Application number: 2020/93859	
What is the application for?:	Erection of single storey extensions and dormer windows to front and rear to for
Address of the site or building:	56, Stile Common Road, Primrose Hill, Huddersfield, HD4 6DE
Postcode:	HD4 6DE

Type of comment: A general comment	
Do you wish your comments to be published on the website anonymously?	No
Comments of	
23 Plane Street, Newsome, Huddersfield HD4 6DF	
Relating to application 2020/62/93859/W at 56 Stile Common Road, HD4 6DE, as a result of the applicant's amended plan, I have again been invited to comment as a direct neighbour of what is currently the garden of the property under development.	
The amendment appears to mostly concern the two-storey garage building. This now plans new access from Plane Street to an upper-storey garage via new driveway on filled ground, but the position, height and profile of the structure appears similar to that planned previously and mostly prompts similar comments. However the change of access results in slight amendments in the updated version of my comments below.	
HOUSE	
I raise no objection to the development of the house as planned.	
GARAGE BUILDING

Title
Site plans and garage details.

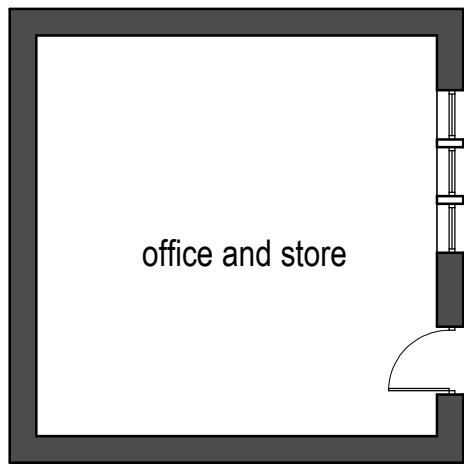
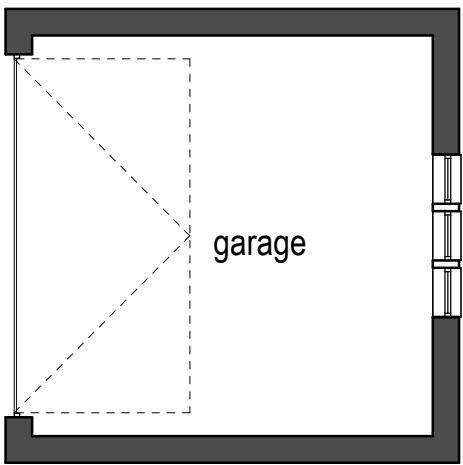
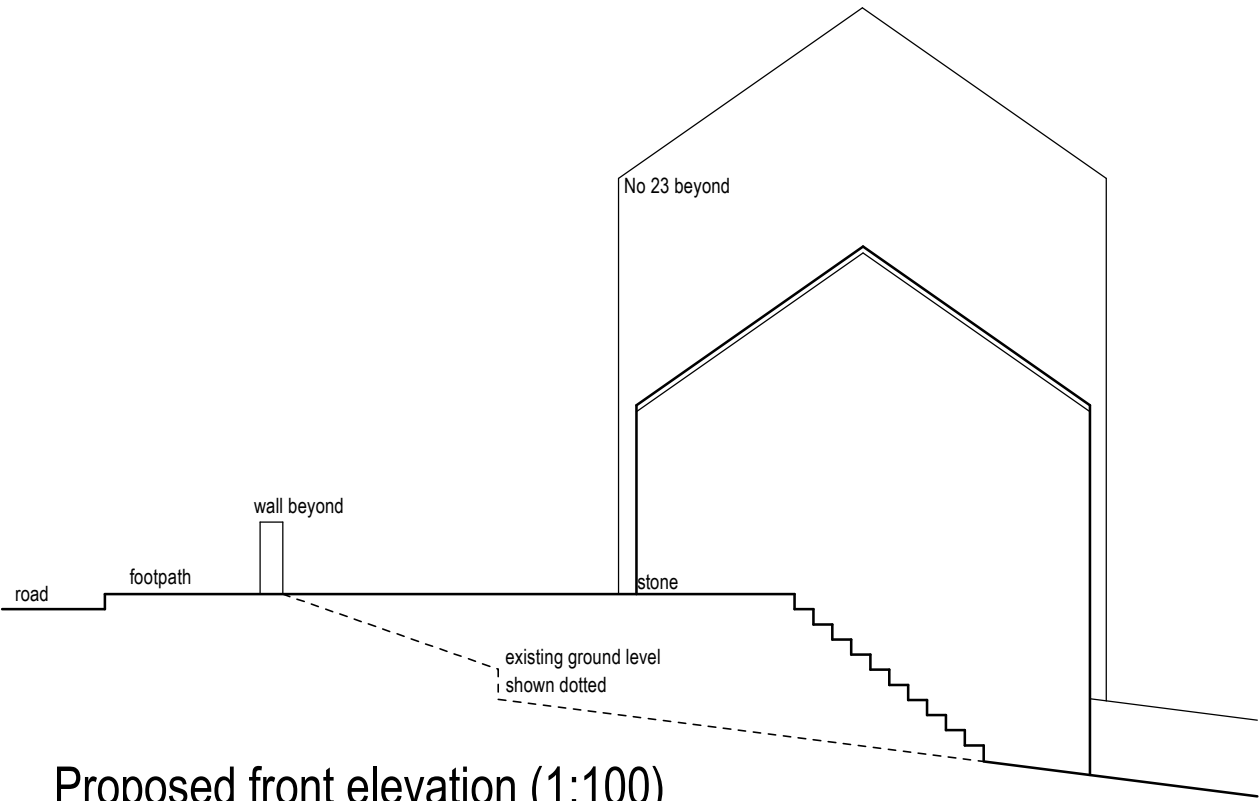
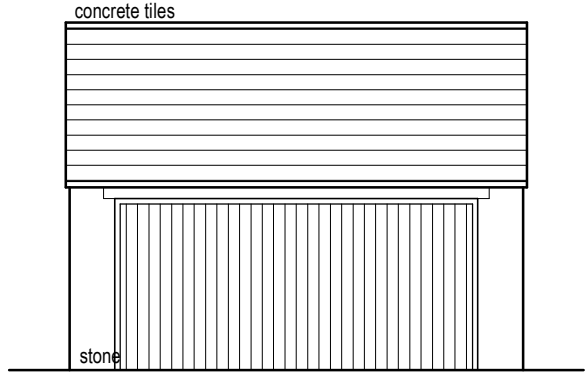
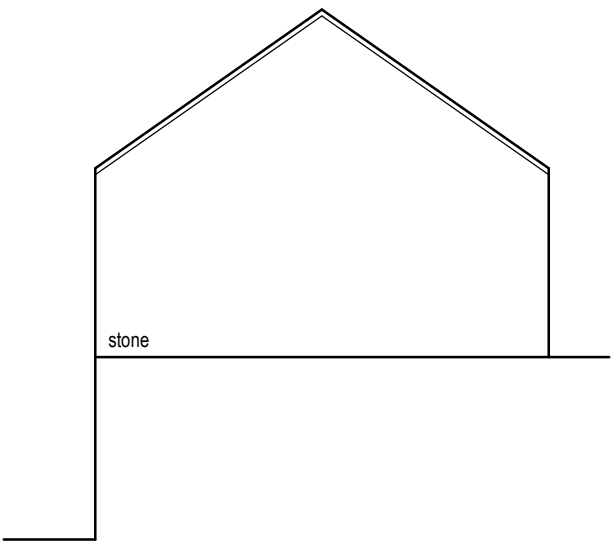
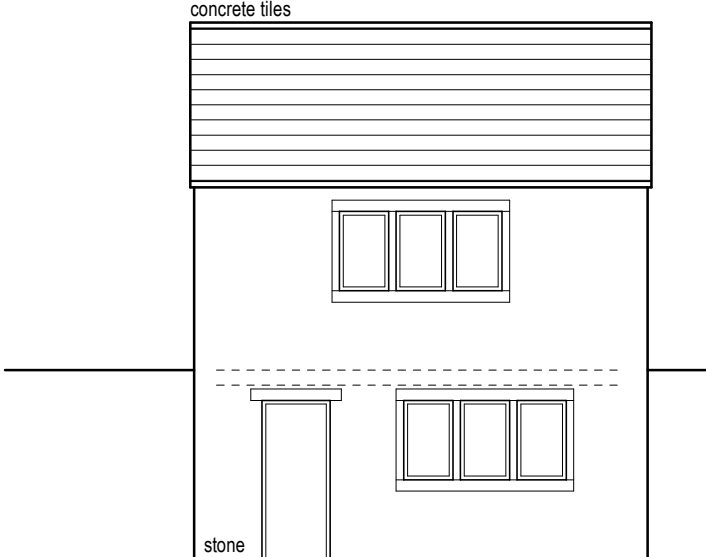
I make the following observations regarding the development of the new two-storey garage building and feel I have no just cause for objection if there are controls addressing these concerns:	
Firstly, the size of the stone building is notably large in its proportions. Its position presents the possibility of shading some sunlight from the side of my property and particularly through kitchen windows at the side door. However, developed according to plan, the height of the building as drawn, together with the distance from the boundary and road as drawn, should keep the development just within a level of tolerance with regard to shading.

I feel that (without further application) any approval of the plan for this building should only be as a domestic garage building and I would wish to see safeguards of this. Any plan for commercial usage would give rise to further considerations regarding storage of commercial materials, potential noise, hours of use and effects of potentially increased vehicle usage or visitor parking.

The developer may need to consider a foundation for a two-storey garage of sufficiency to avoid any possibility of ground subsidence.

Proposed site plan (1:200)

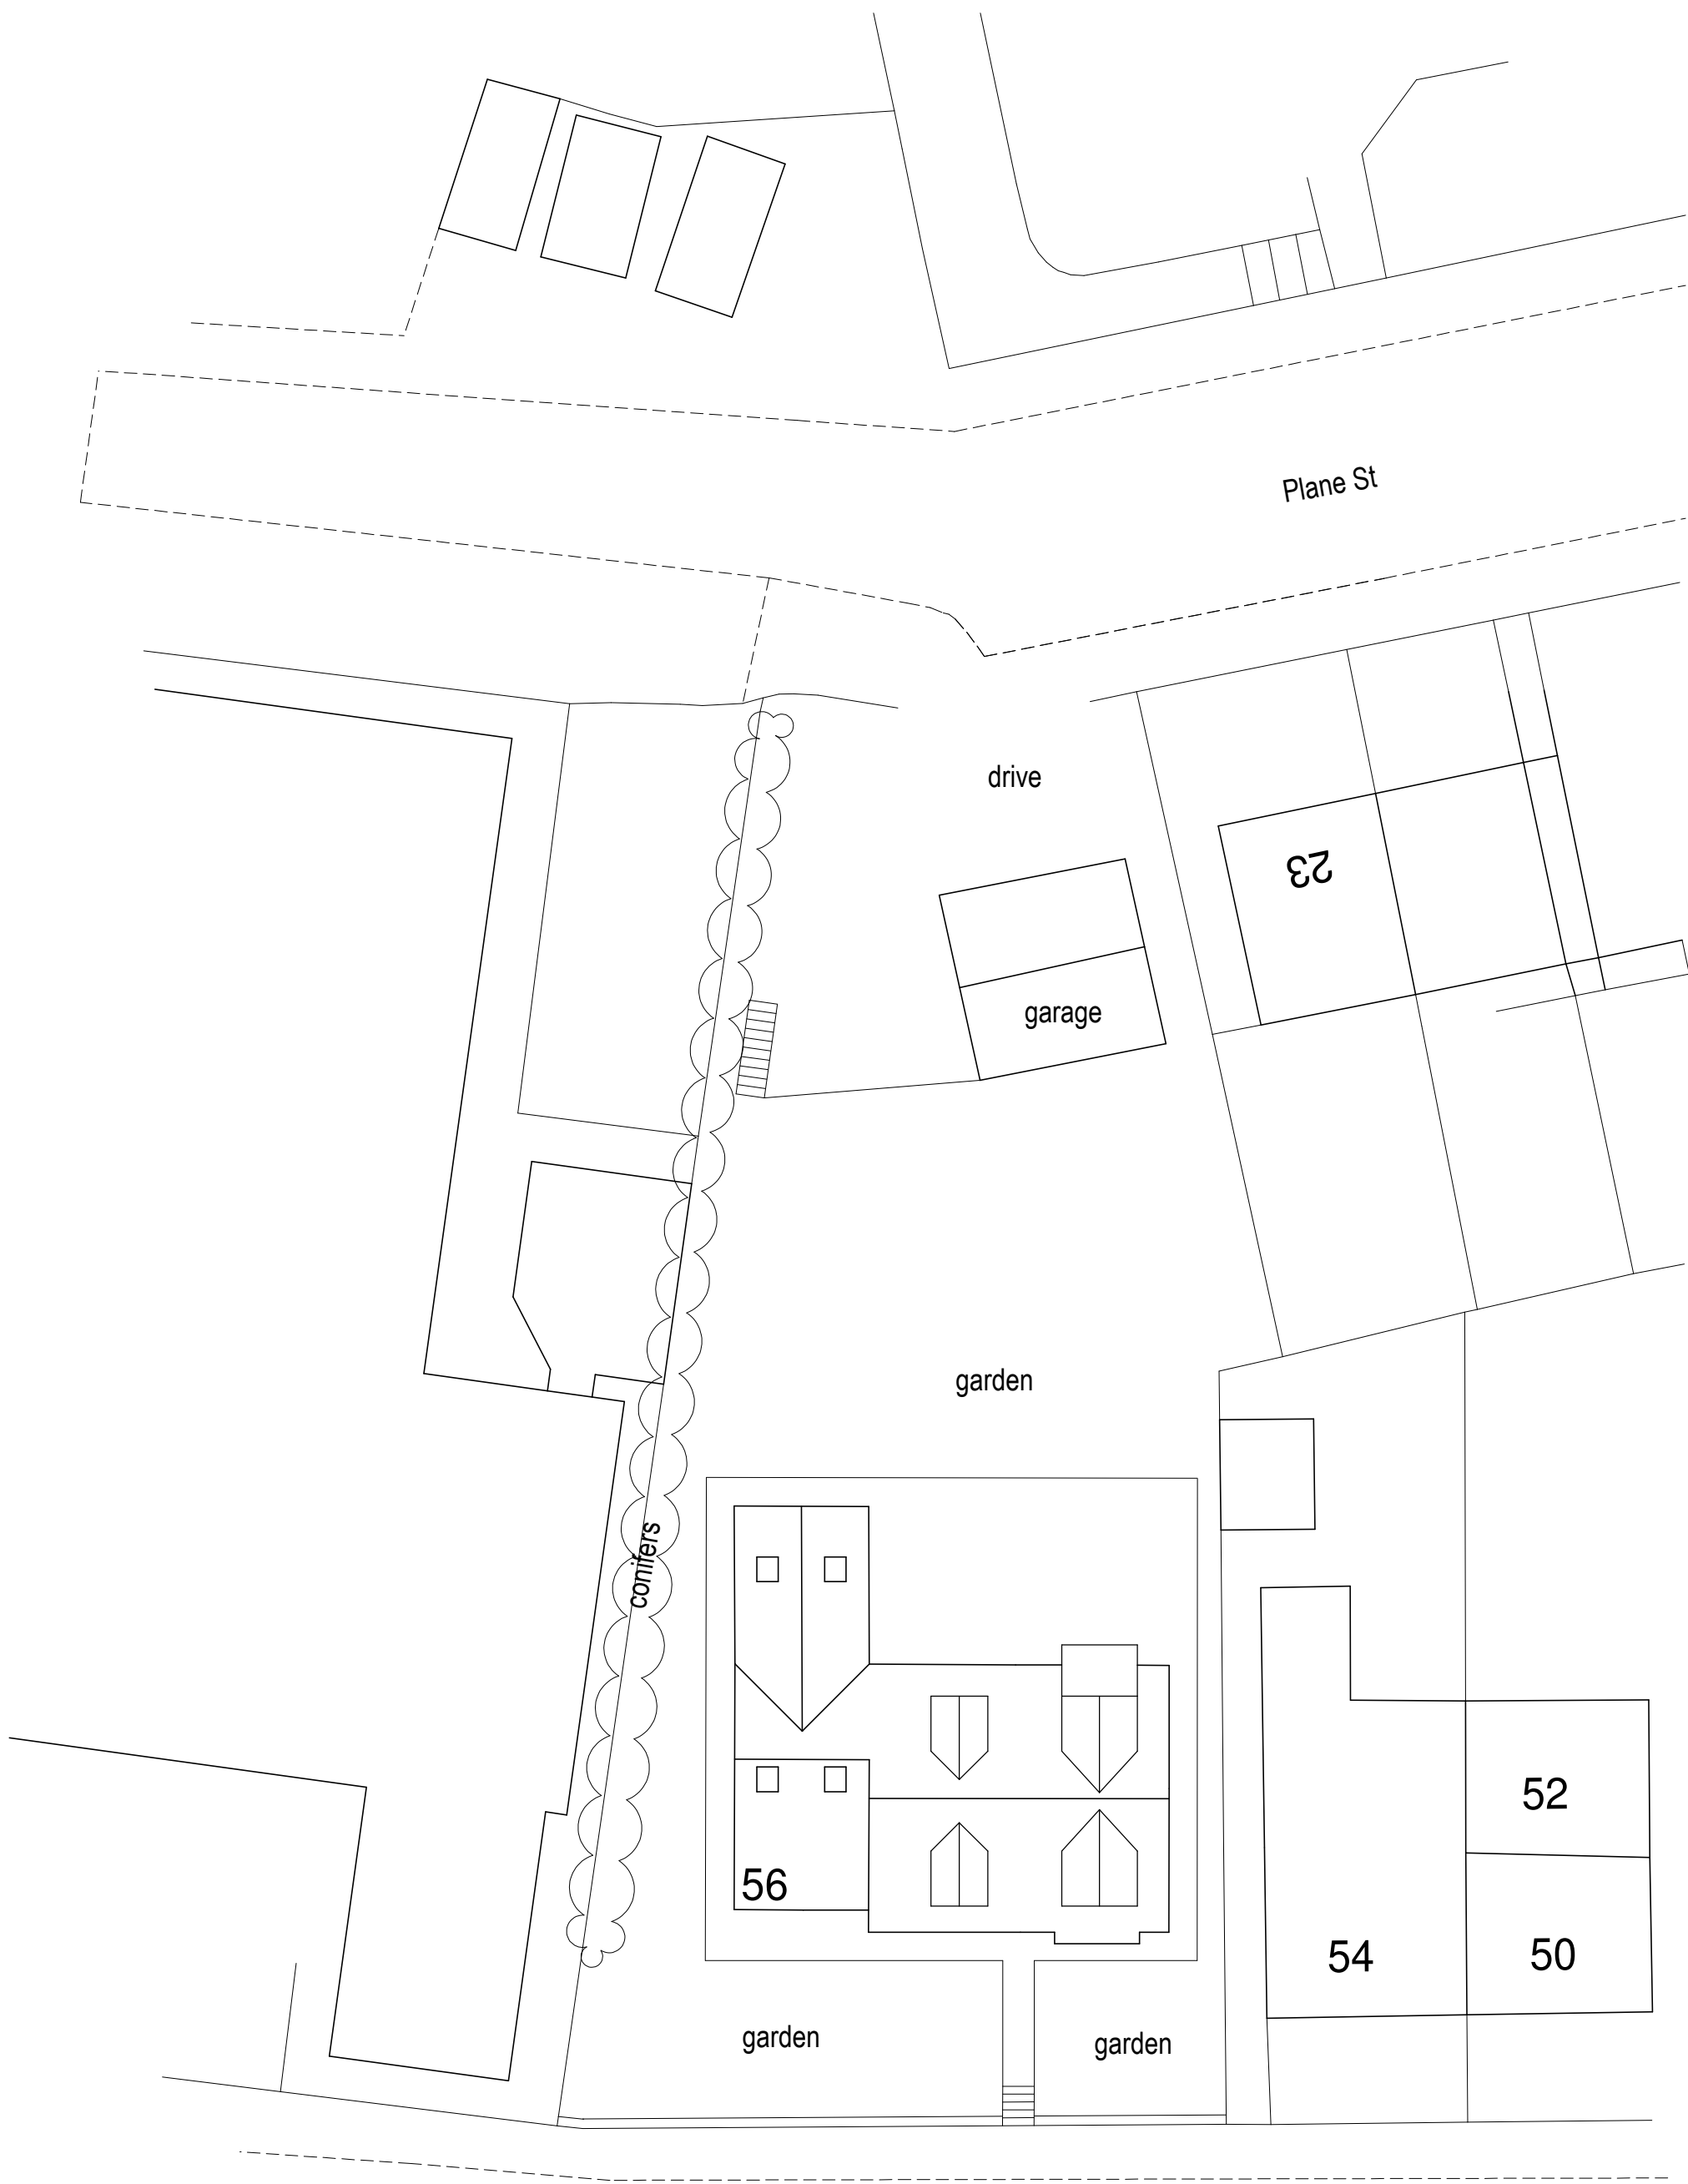
While I can appreciate the applicant might see benefit of more direct linkage with Plane Street than the current gated rear driveway, it is difficult to envisage from plan how the new driveway access position would fit with the current road curtilage, this being at the juncture of unmade road with verge and the made street with pavement (but without effective street drainage at this position).

The plan here shows non-inclusion of the "trees and foliage" in the proposal drawing, however the applicant's form indicates 'No' to the question of "Will any trees or hedges need to be removed or pruned to carry out your proposal?"

I would like to see some control of this through the planning process, if possible. In particular, the removal of the Leylandii conifer tree high hedges next to the boundary of 23 Plane Street. These would become much more difficult to manage for their fast-growing height in the space between the new garage building and boundary wall. Notwithstanding this, the planting of garden boundary vegetation of manageable proportions is to be welcomed.
